From: Mundy, Ben - Oxfordshire County Council <Ben.Mundy@Oxfordshire.gov.uk>
Sent: 25 January 2023 15:51
To: Shona King; DC Support
Cc: Transport CDC Minor
Subject: 23/00075/DISC The Chaff Place Caravan, High Street, Bodicote, OX15 4BS

SITE PLAN
(Scale 1:200)

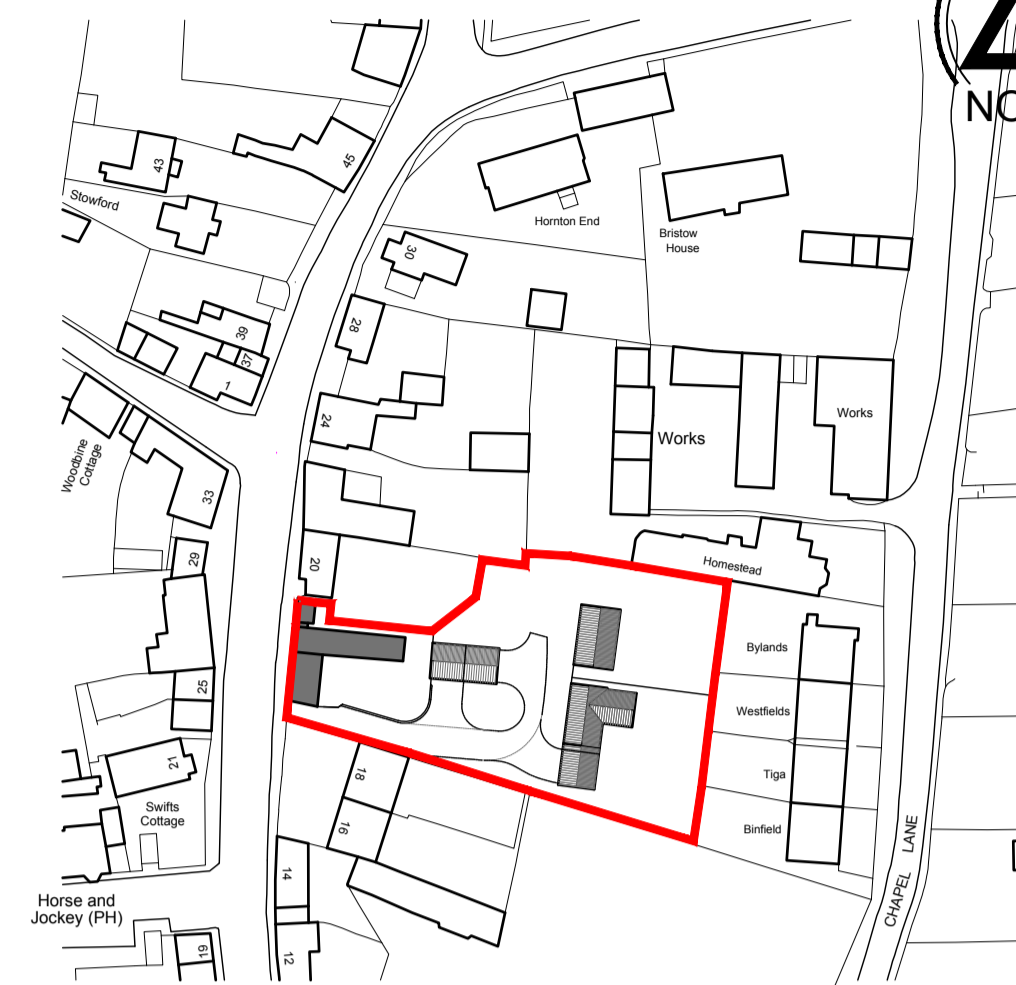
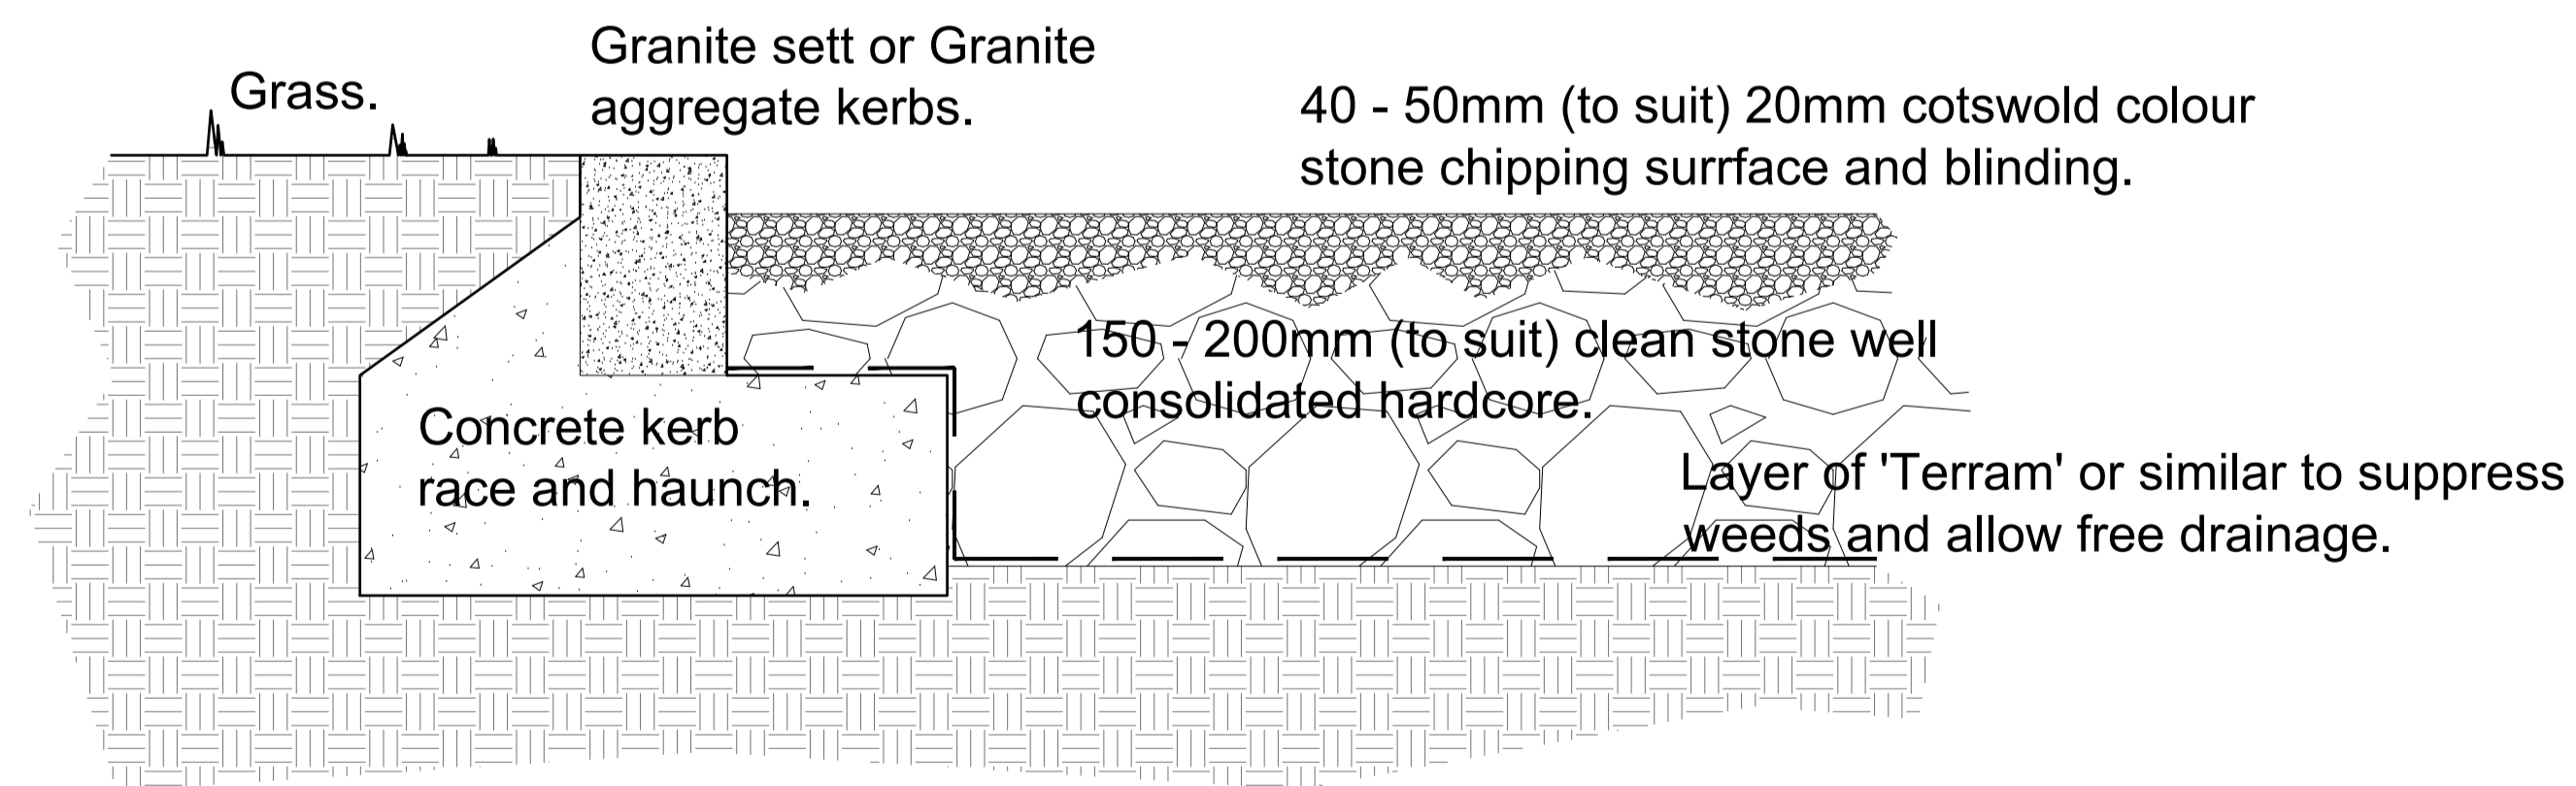
The manoeuvring areas for this development are adequate, however the garage space for both plot 1 and 2 are not large enough to be considered sufficient vehicle parking spaces. OCC's Street Design Guide states that for a garage to be adequate parking it must measure 3m x 6m and a double garage 6m x 6m, the garages will therefore need to be amended to ensure they are fit for purpose.
